West Burton Solar Project

Schedule of Changes Revision B (Deadline 3)

PINS reference: EN010132
Document reference: EX3/WB8.1.8_B
The Infrastructure Planning (Examination Procedure) Rules 2010
Rule 8(1)(k)

Figure 8.18.2: Landscape and Ecology Mitigation and Enhancement Measures West Burton 2 Revision A

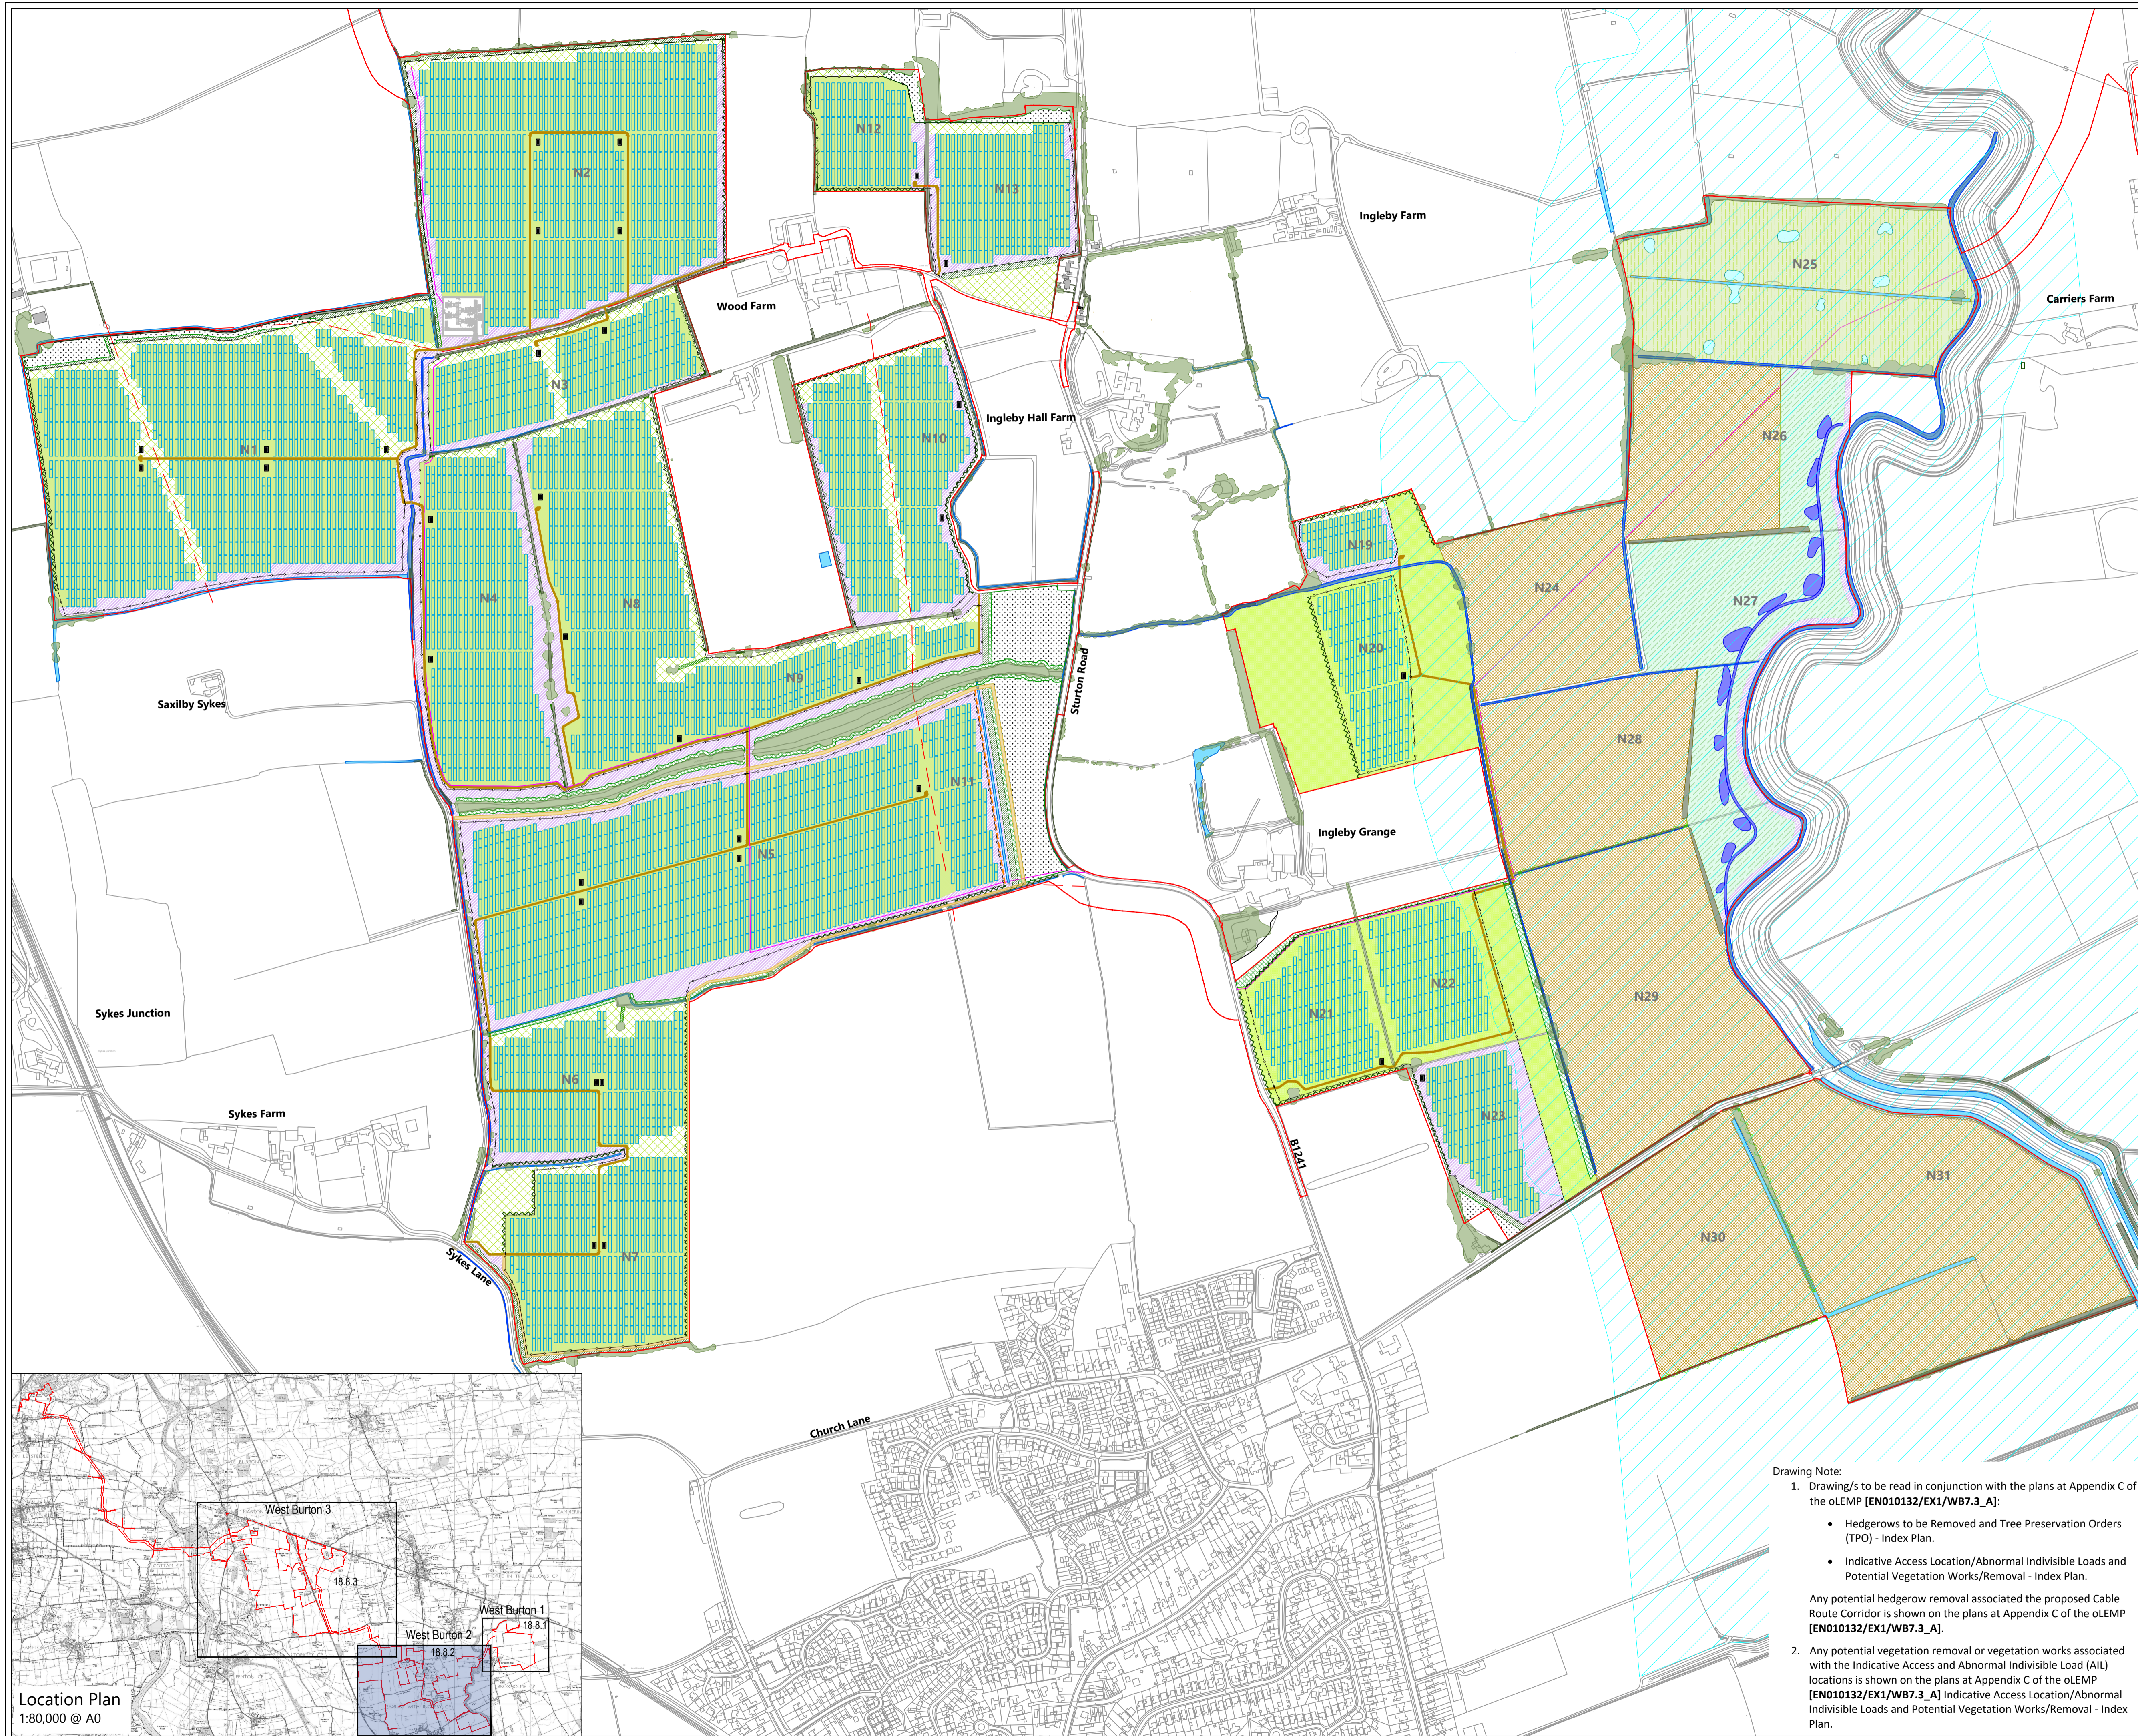
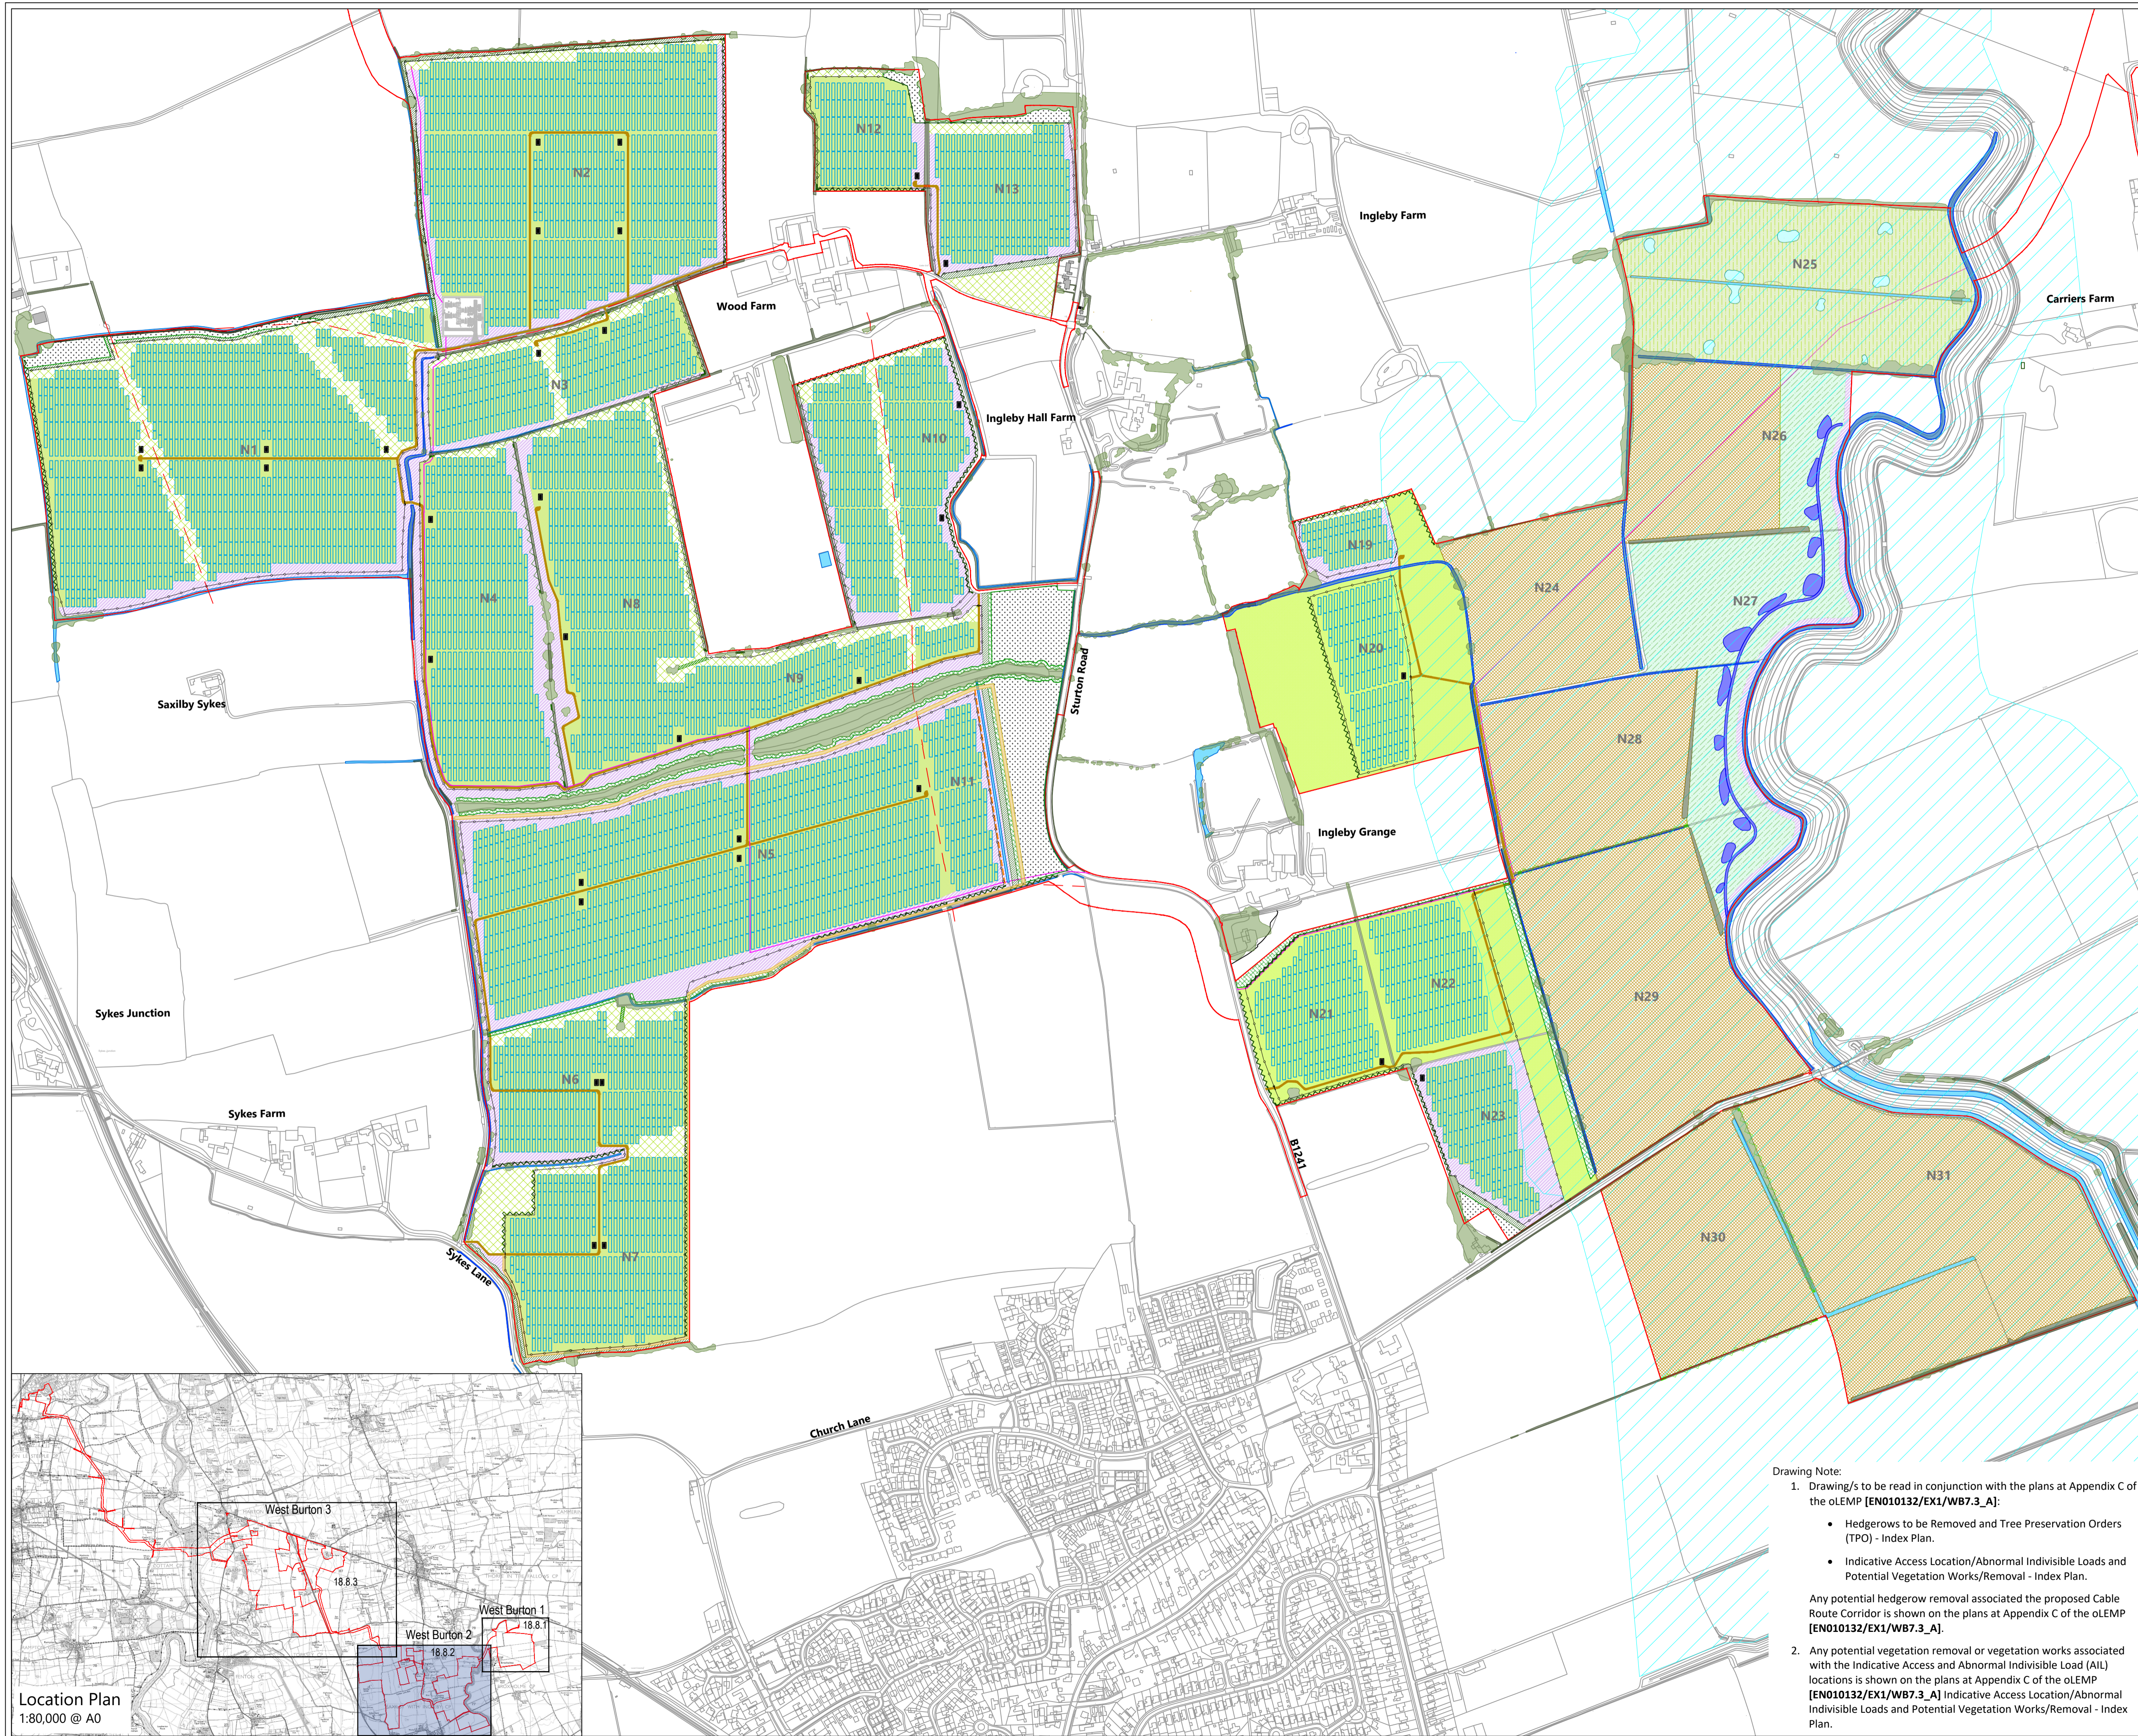
Document Name	Submitted Document Reference	Revision and New Reference	Change	Reason for Change
Measures - West Burton 1				
WB6.4.8.18.2 ES Figure 8.18.2 - Landscape and Ecology Mitigation and Enhancement Measures - West Burton 2	[APP-282]	Revision A [EX1/WB6.4.8.18.2_A]	Correction of typos, to show additional hedgerows to be removed and to provide clarity of IDB Drain locations.	Minor editorial changes for clarity.
WB6.4.8.18.3 ES Figure 8.18.3 - Landscape and Ecology Mitigation and Enhancement Measures - West Burton 3	[APP-283]	Revision A [EX1/WB6.4.8.18.3_A]	Correction of typos, to show additional hedgerows to be removed and to provide clarity of IDB Drain locations.	Minor editorial changes for clarity.
WB6.5 Environmental Statement - Non-Technical Summary	[APP-308]	Revision A [EX1/WB6.5_A]	Paragraphs 6.3.60 to 6.3.62 corrected to show that the significant effects are adverse.	To correct typographical errors.
